FOSSE GREEN ENERGY EXAMINATION

COMMENTS ON THE APPLICANT'S DRAFT ITINERARY FOR THE ASI

ANDREW KEELING (IP Ref: [REDACTED])

Site Access Location Plan

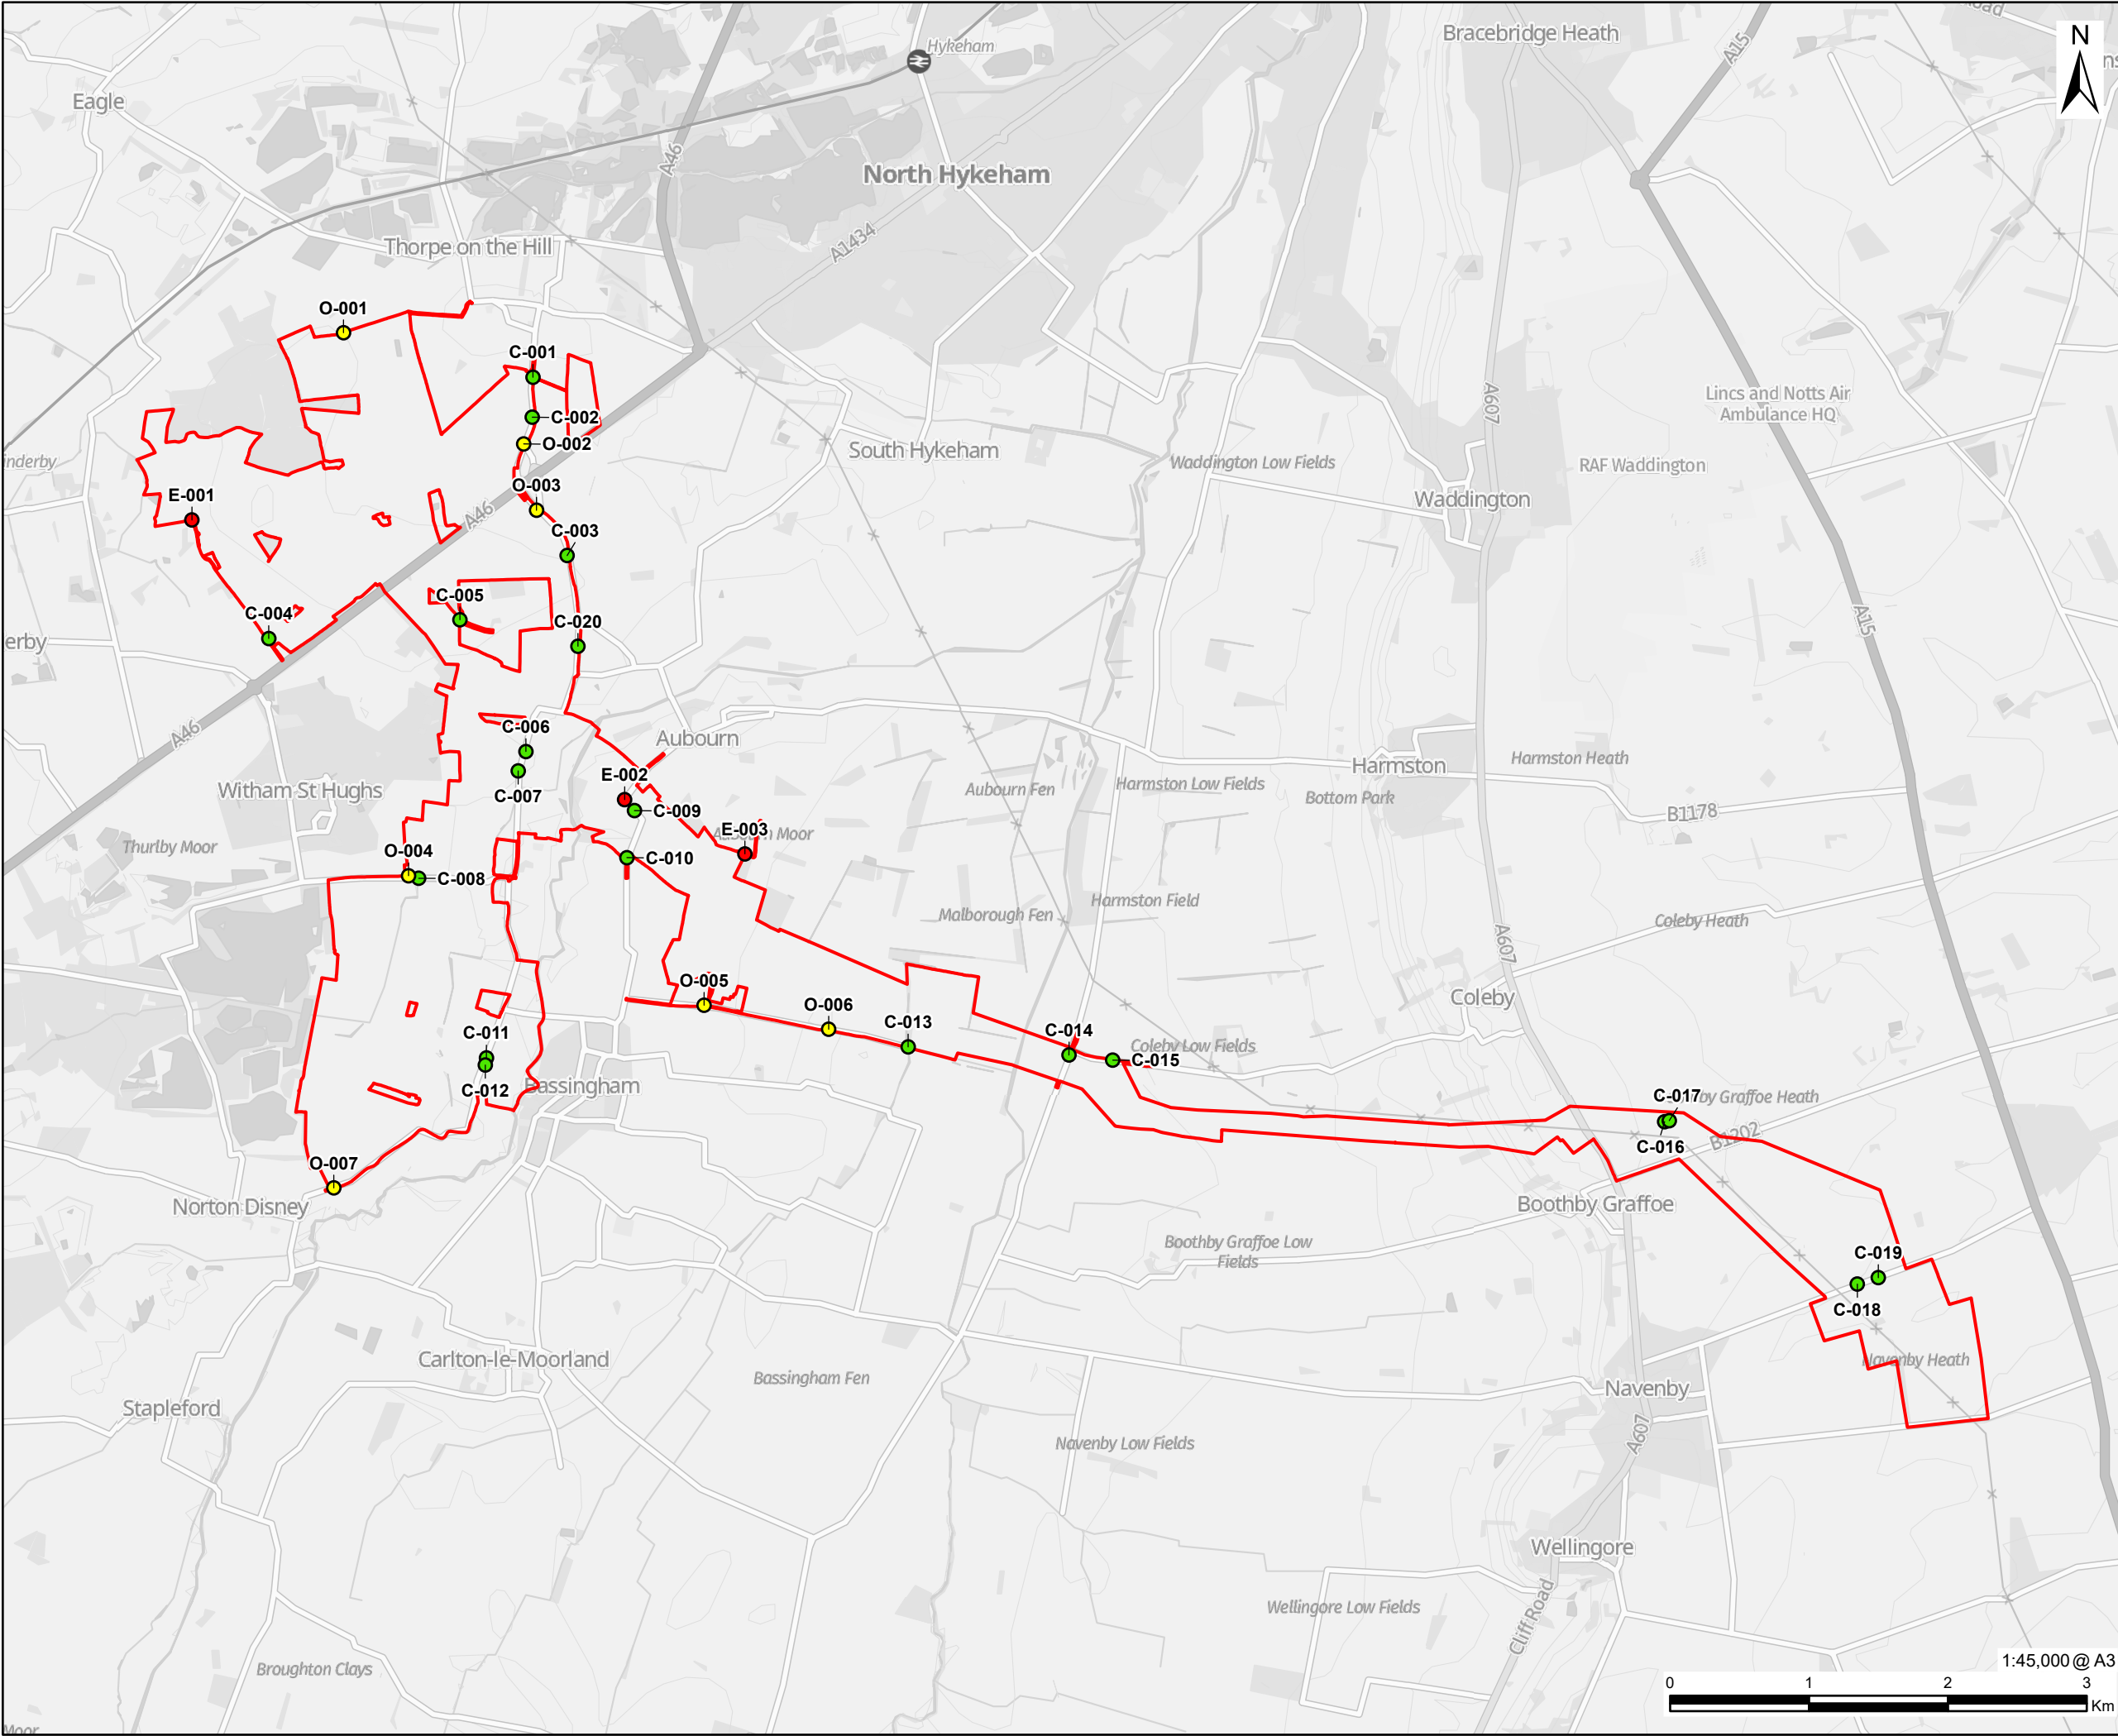
I would ask the ExA to consider the suitability of Clay Lane for HGV traffic. The lane is very narrow and has very few passing places. It is also heavily potholed. HGV traffic will almost certainly result in a further deterioration of the surface of the lane.

Bird Mitigation Land Allocation

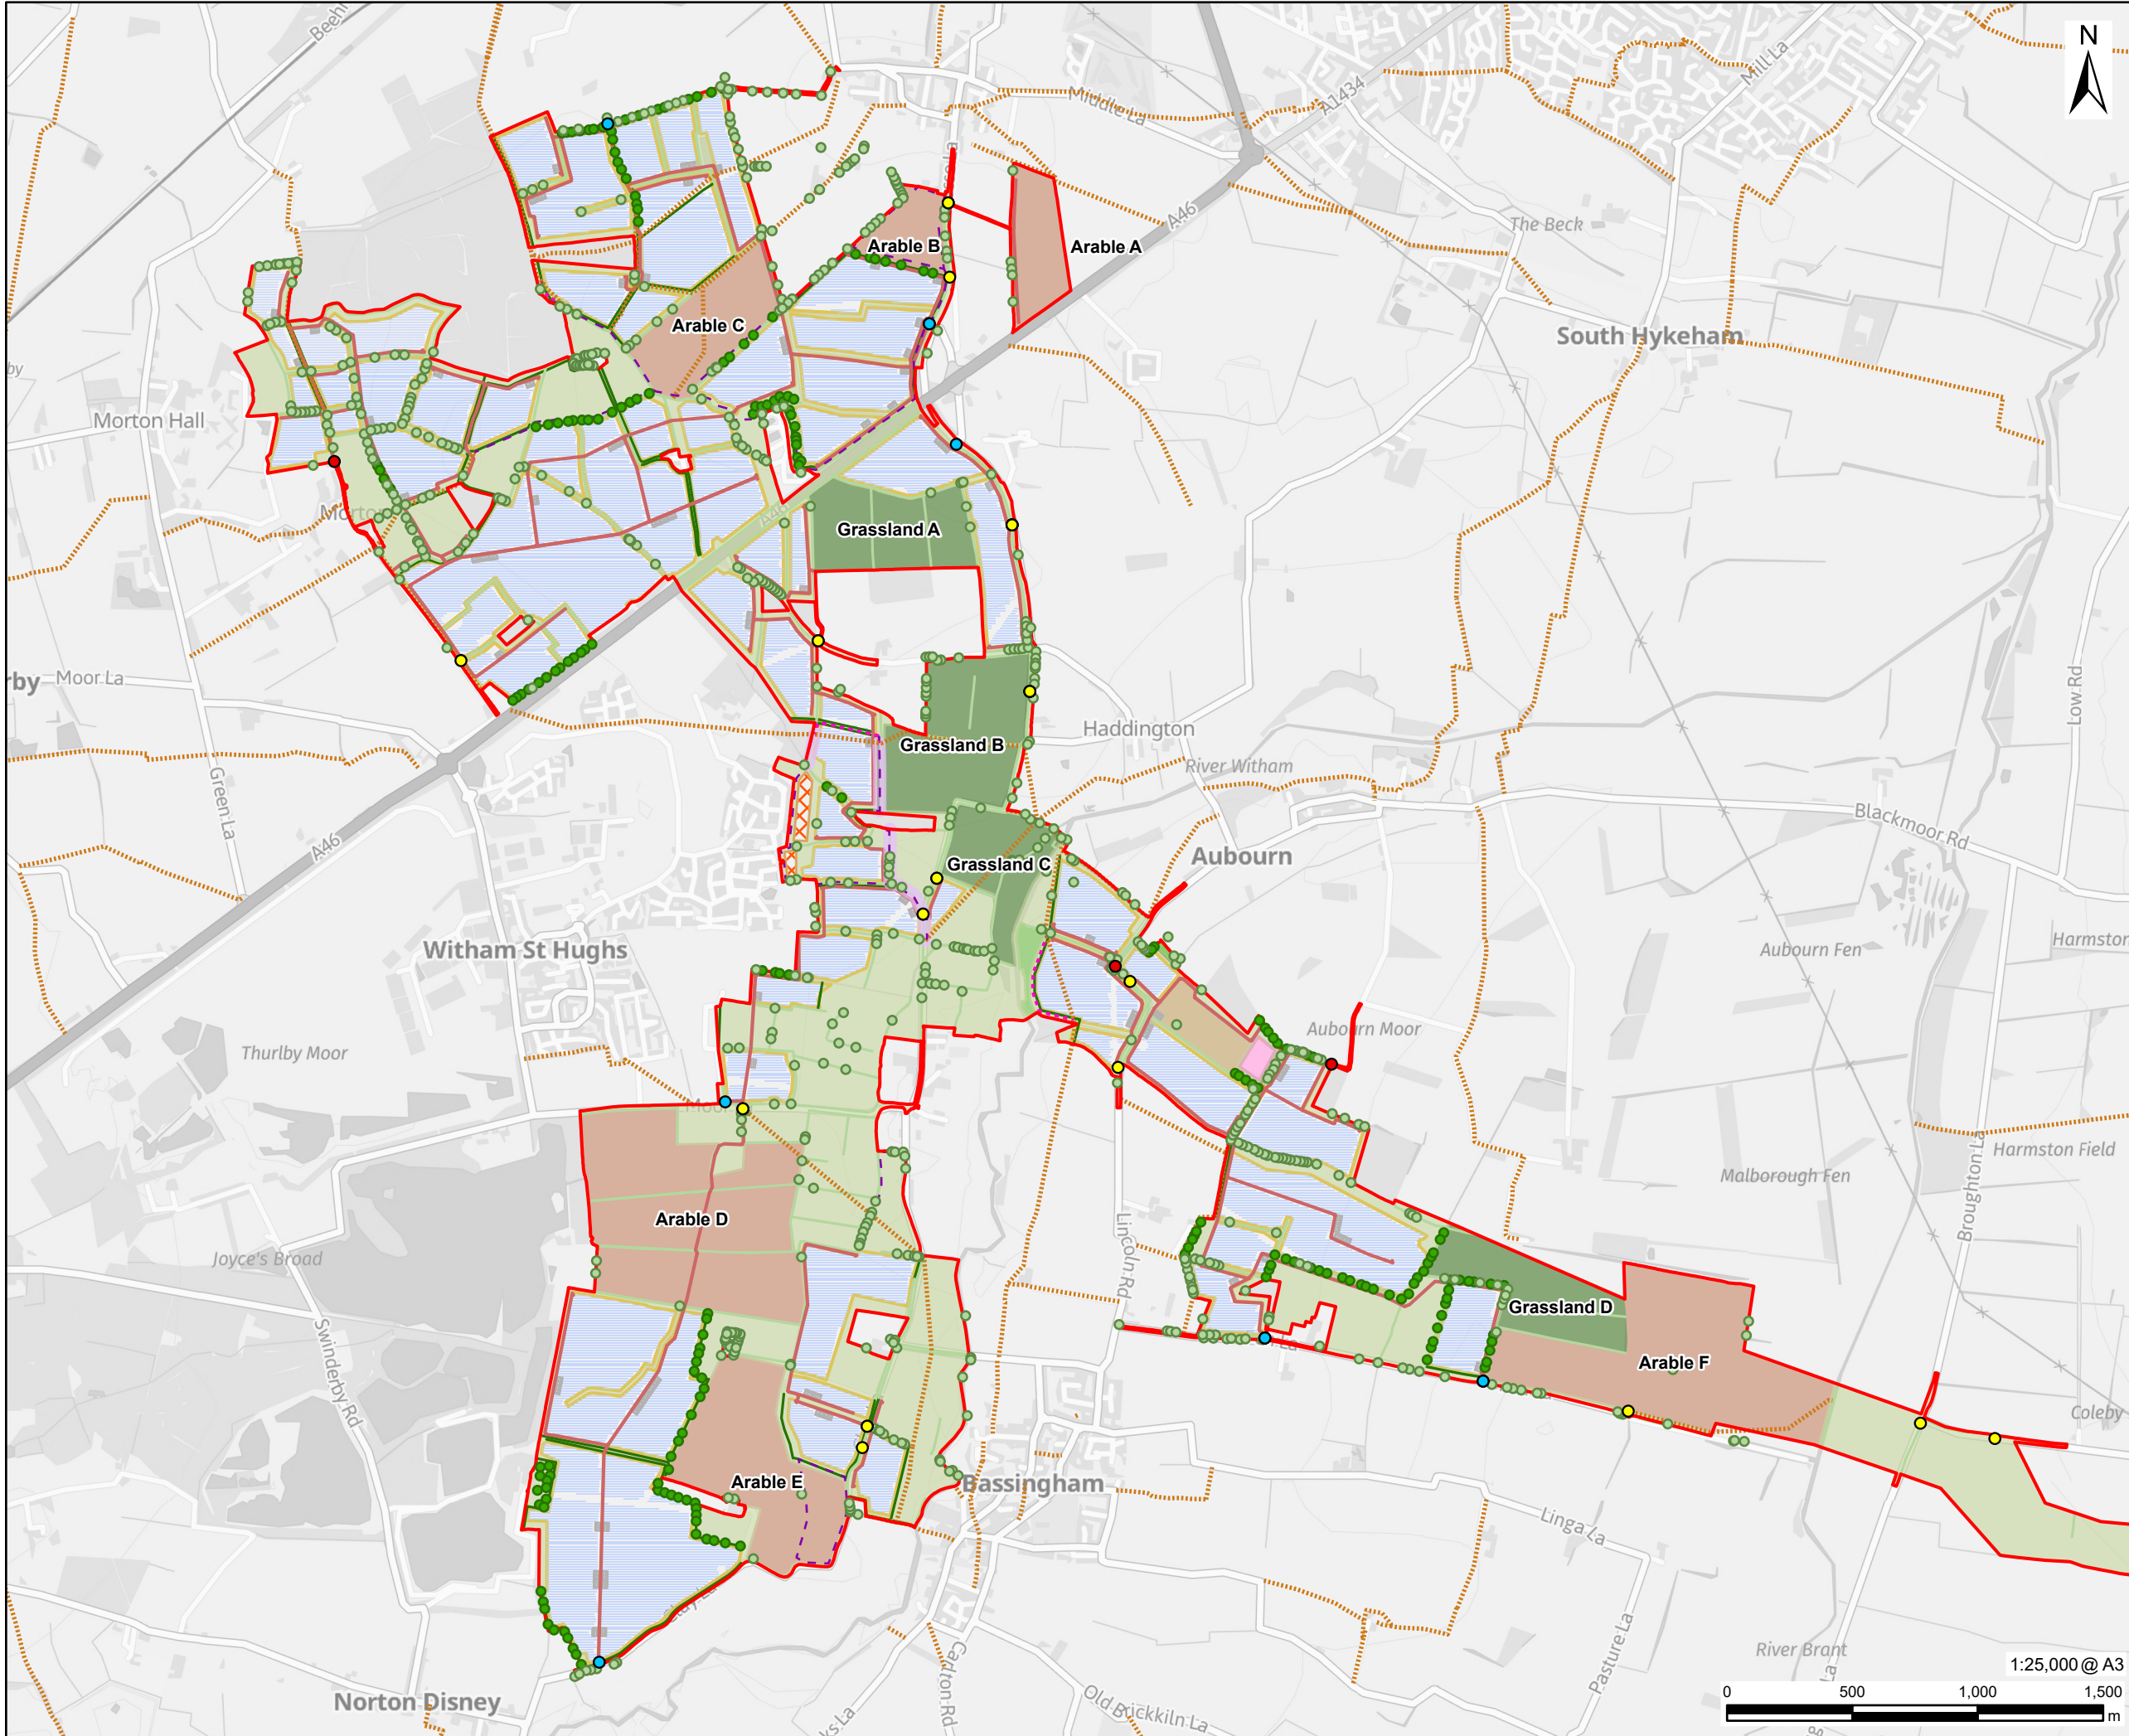
The applicant is keen to show the ExA the site of its proposed circular permissive path route located within the proposed bird mitigation area, which they are claiming as a benefit of the Fosse Green Energy project. I would ask the ExA to consider how appealing this proposal will be for recreational purposes. It will be on a flat, featureless piece of land, with views of solar panel arrays to the north, and more distant views of solar panels to the west. I can't see it having much appeal as a recreational facility for Bassingham residents. The village already has a good local recreational facility at Holmes Parish Woodland and the footpath to the east of Clay Lane, which is used for circular walks around the village. As far as I am aware the applicant has not undertaken any consultations to establish whether Bassingham residents would welcome and use the proposed permissive path route, so do not believe that they can legitimately claim it as a benefit. It is only a benefit if there is evidence that local people will use it.
